SUBMISSION TO WEST SUSSEX COUNTY COUNCIL FOR DEPARTURES FROM STANDARD

Project Name	BEW Parcel SC1 - Form 2
Applicant Organisation	CC Projects, Ashmarden Ltd, Hanbury (PM)
Applicant Ref	BEW Parcel SC1
Highway Authority Ref	ADC Ref BN/11/22/OUT
Applicant Contact Details	Terance McLaughlin Pell Frischmann 07958039622
Date Submitted	17.07.2023 - Rev4

A	Discipline	Road Geometry at proposed Hanbury Roundabout Junction on existing Lidsey Road
	Type	
B	Relevant Standard(s)	CD116 - Geometric design of roundabouts
	Clause	Section 3.36 - Visibility
C	Difference Between Standard(s) and proposed design	The standards for 70A kph design speed is 120m forward visibility on approach On northbound approach to proposed roundabout 120m is achieved. On southbound approach to proposed roundabout 65m is achieved.
D	Reason for Departure (overview)	Land ownership and maintaining visibility splay within either public highway or developer land
E	Associated Project Departures	
F	Other Options Considered	Moving roundabout. This is not considered possible because moving either north or south visibility and land ownership becomes even more problematic

Drawing No. **A13394-PF-ZZ-SK-DR-CD-01001** Revision **P01**

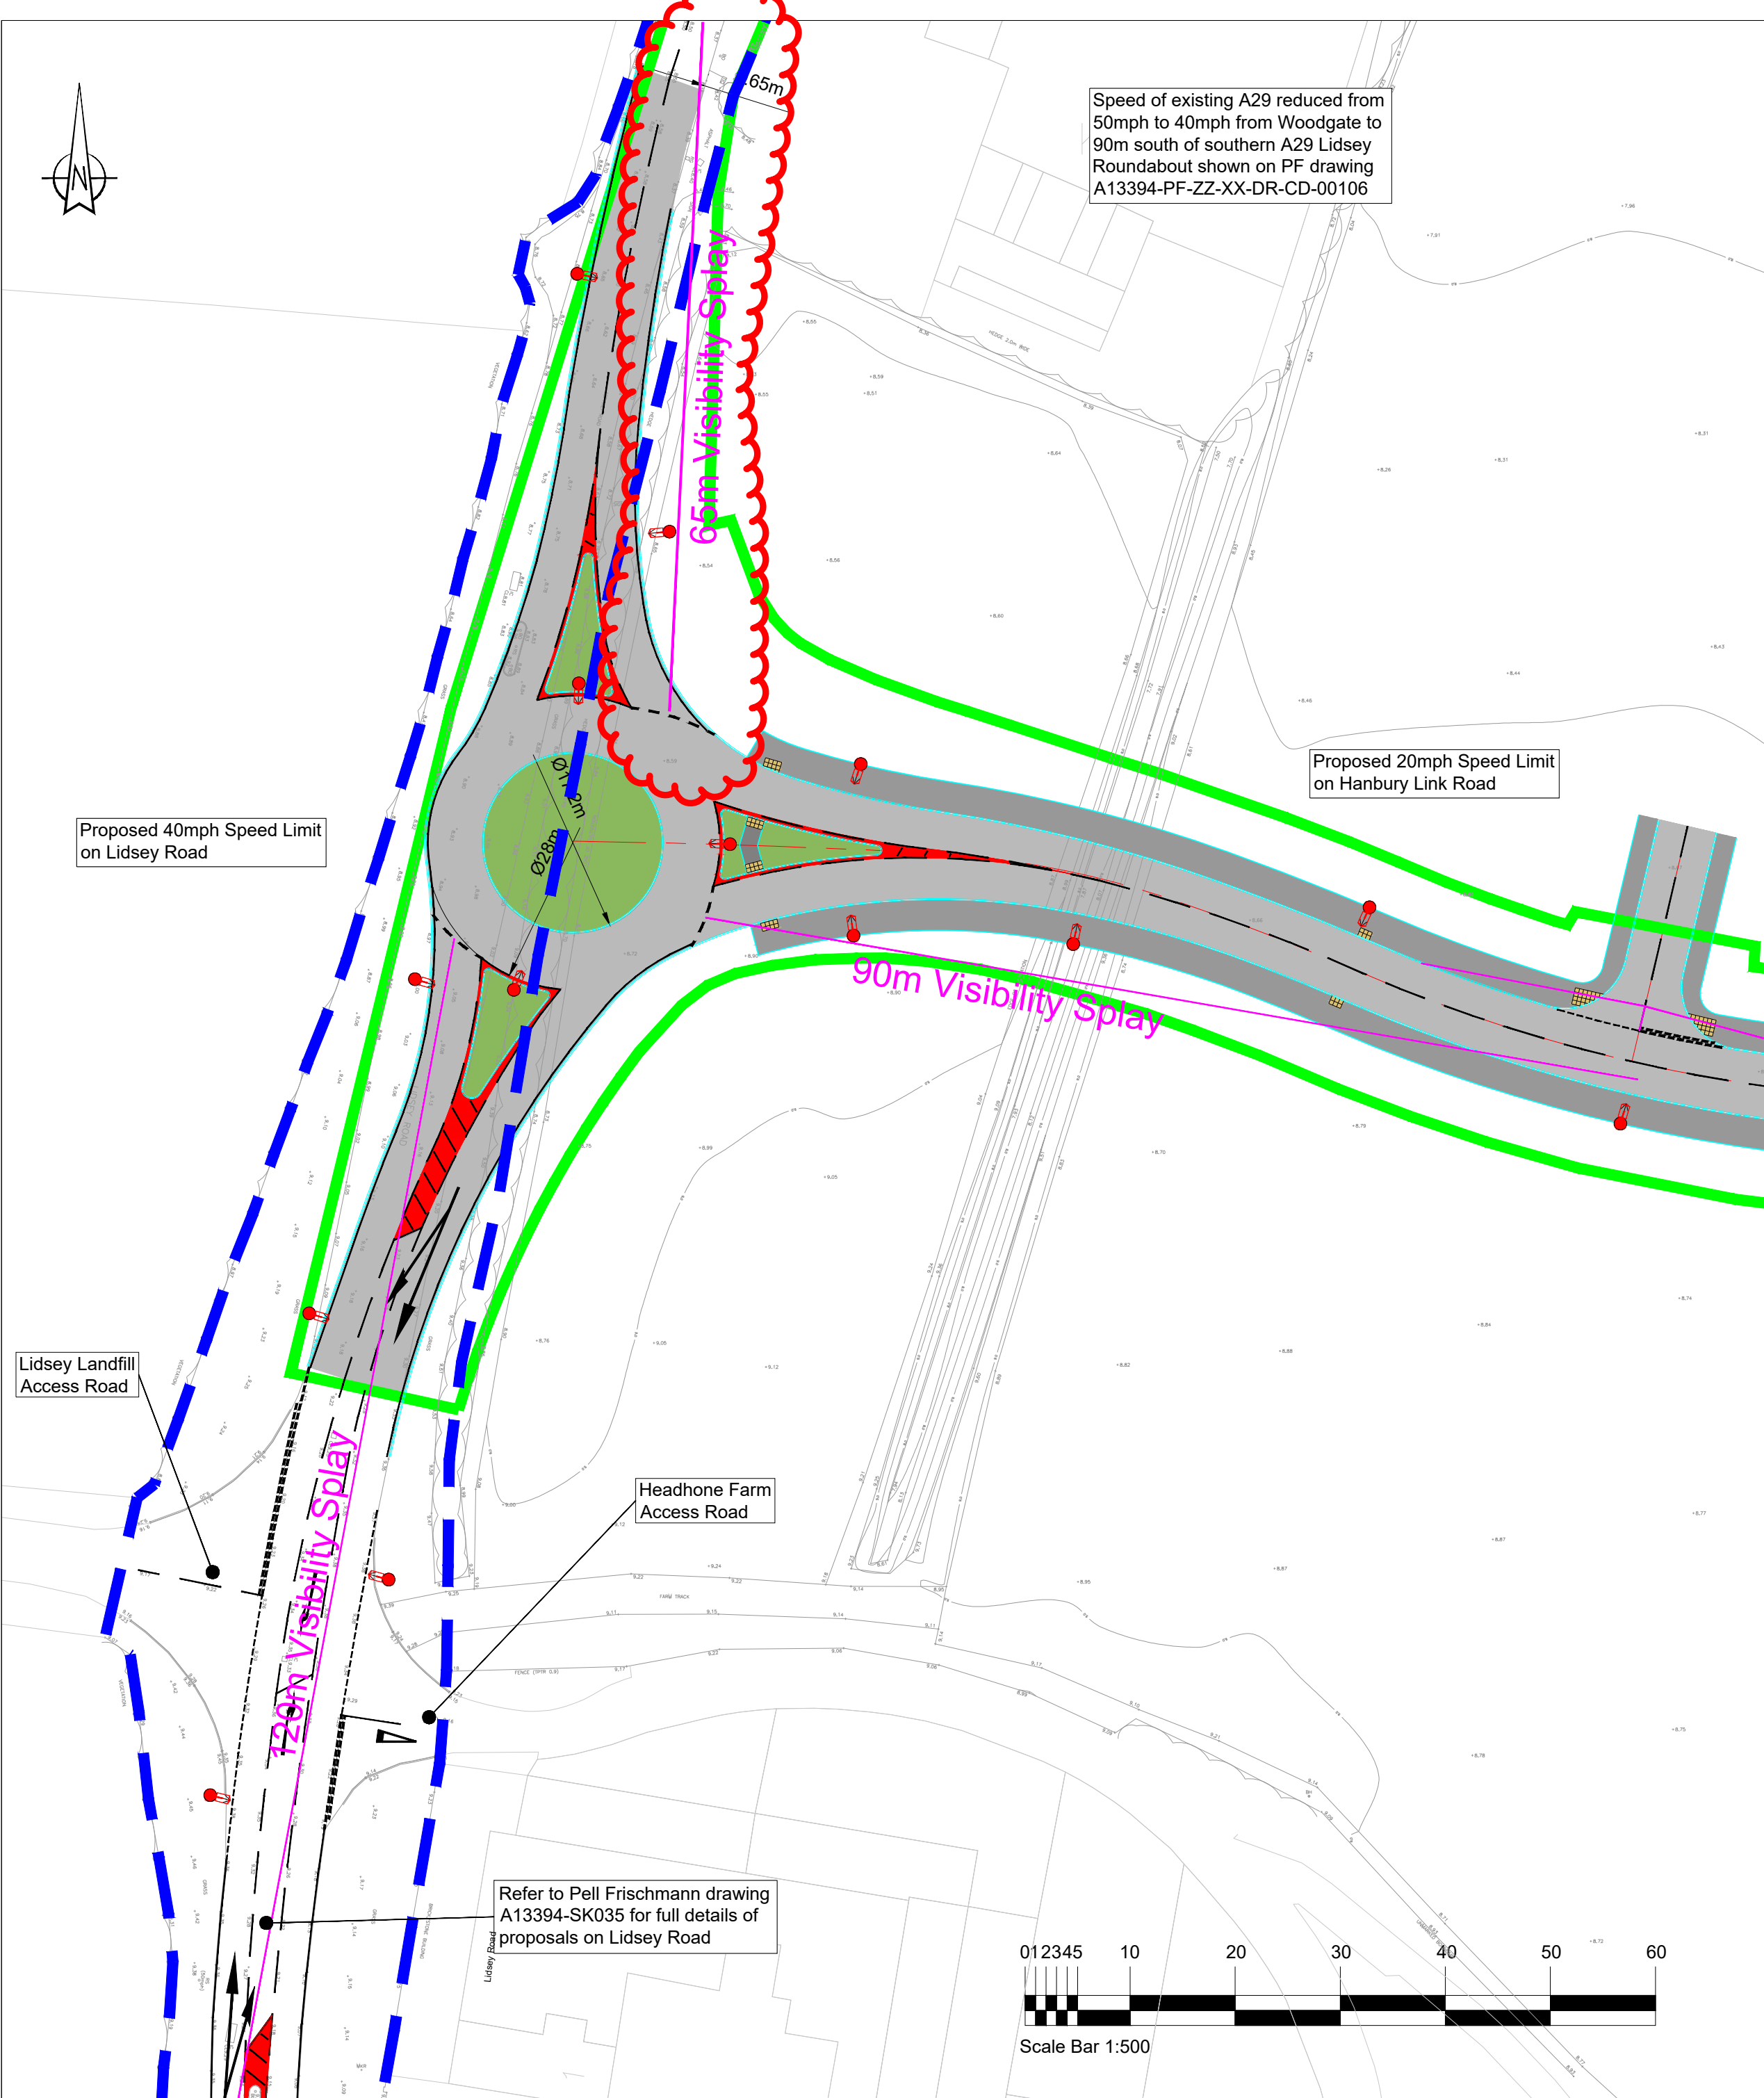
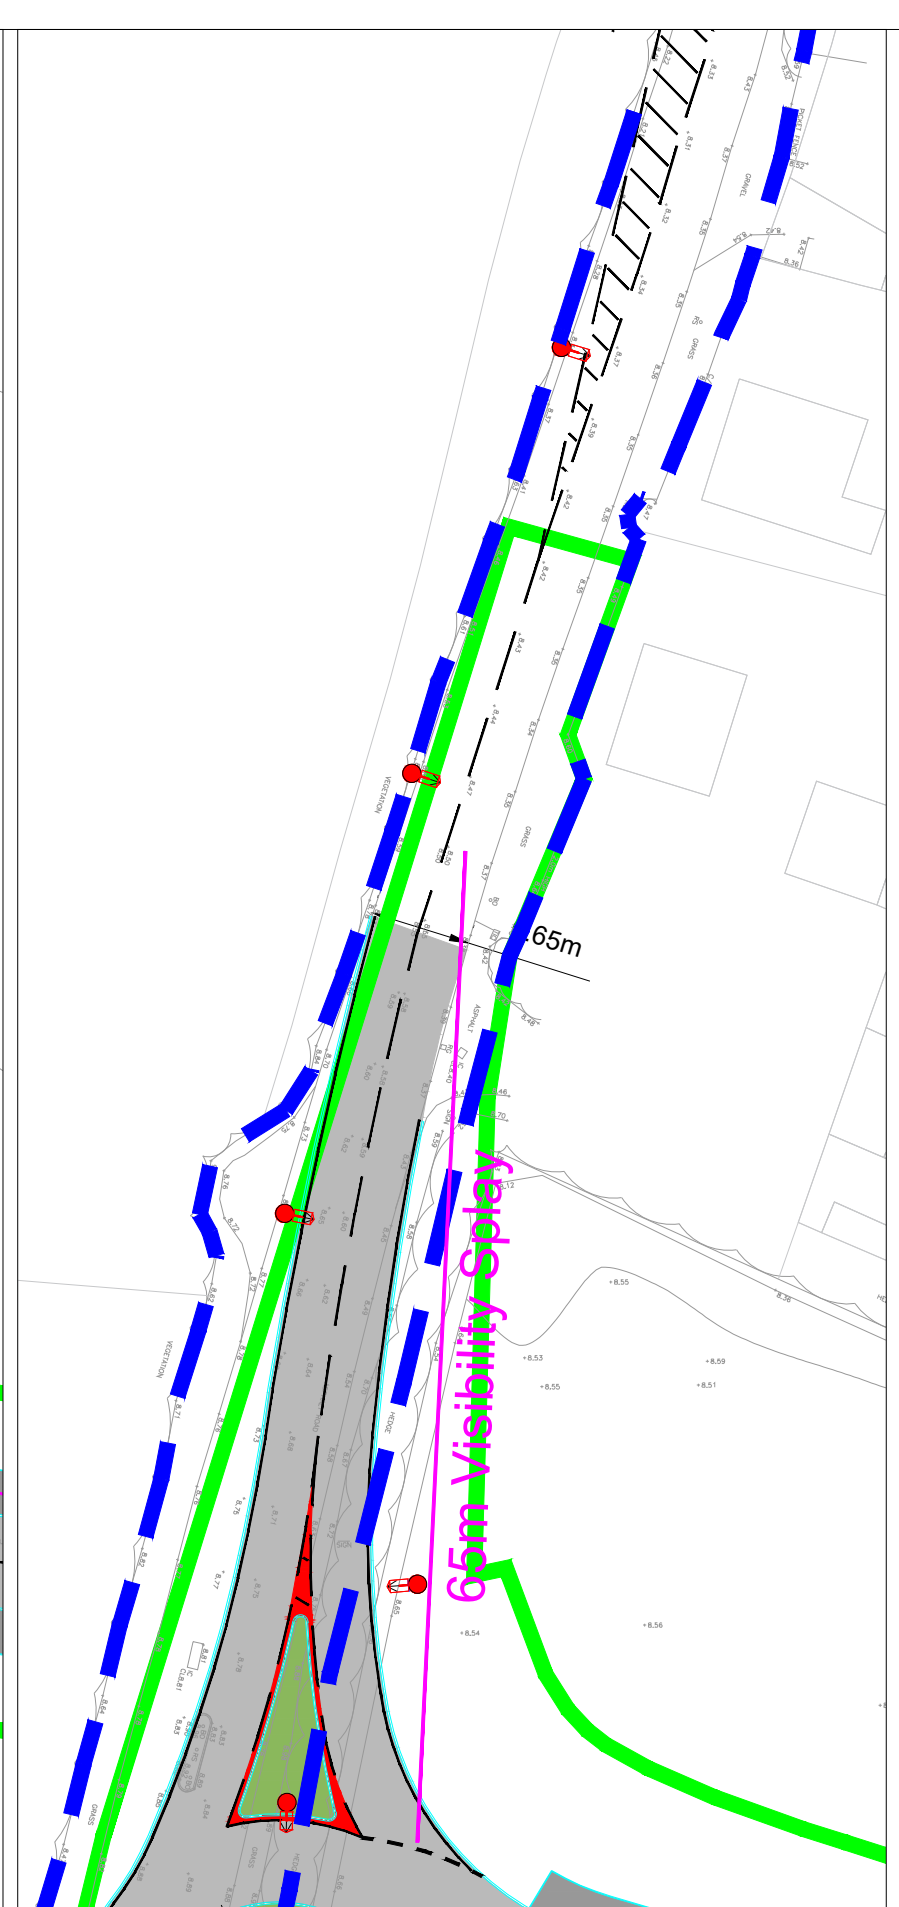
NAME 1	David Lambert		
ROLE	Lead Professional - Highway Design		
SIGNED		DATE	
NAME 2	Alex Sharkey		
ROLE	Improvements Team Manager		
SIGNED		DATE	
MARK ONE BOX:	1- APPROVED ☐	2-APPROVED WITH COMMENTS ☒	3- REJECTED ☐
COMMENTS	Approved subject to the following: 1) An internally illuminated 'keep left' bollard shall be installed at the northern point of the northern splitter island such that it is visible from a point 120m north of the give way line. 2) A chevron sign to diagram 515 shall be mounted on the roundabout central island in a position such that it at least 2 chevrons are visible from a point 120m north of the give way line. 3) Either a pictorial ADS sign showing the form of the roundabout, or roundabout warning sign(s) sized and sited in accordance with Traffic Signs Manual Ch 4, shall be sited on the southbound approach to the roundabout such that it is viewable from a point at least 120m north of the give way line. If a warning sign is used consideration may also be given to the use of an accompanying 'SLOW' marking. If an ADS is used a warning sign will not be required unless it is deemed to be necessary through the road safety audit process.

A	Included Measures	Additional signage and red markings proposed to be introduced to reinforce speeds. This is to be developed at Detailed Design Stage
B	Rejected Options
